Our Ref: LU/83/19/CLP
Your Ref:

Application for Lawful Development Certificate for a Proposed Use or Development

Development Lawful development certificate for the proposed use of existing dwellings as 2 No. separate dwellings.
Location 41 Western Road Littlehampton

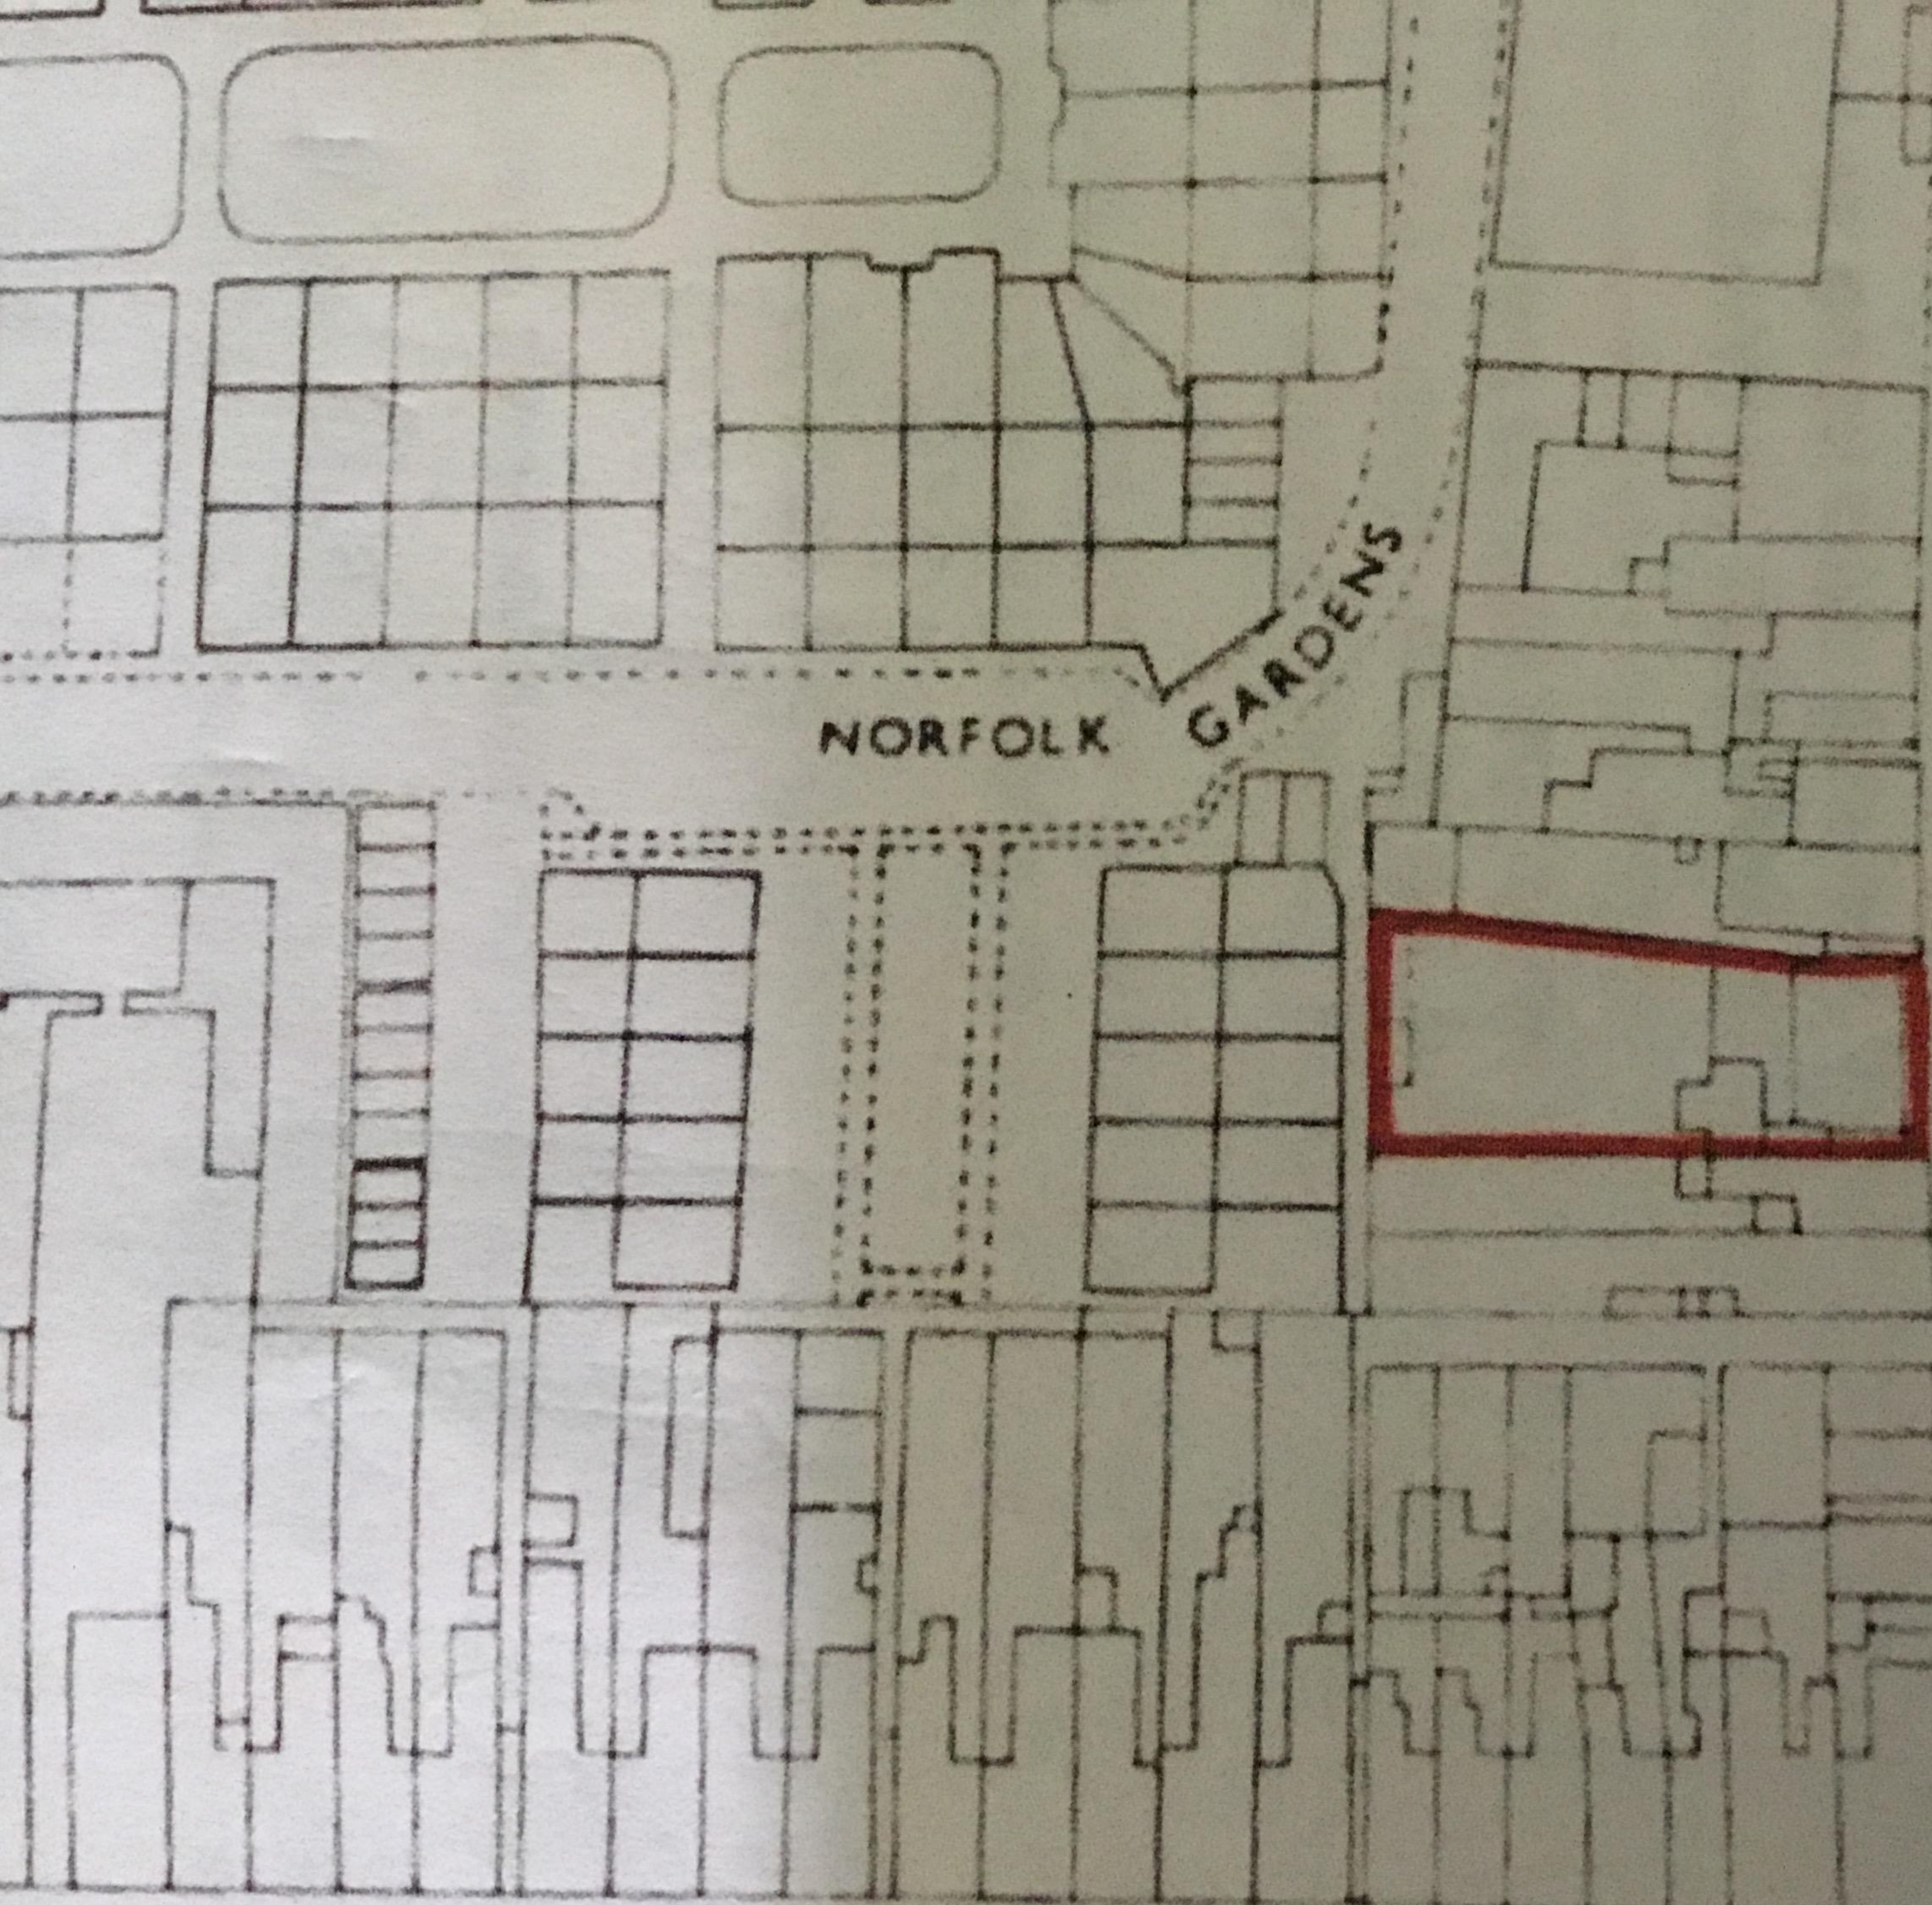
Location Plan Amend

Please provide this plan at an identifiable scale and provide a north point.
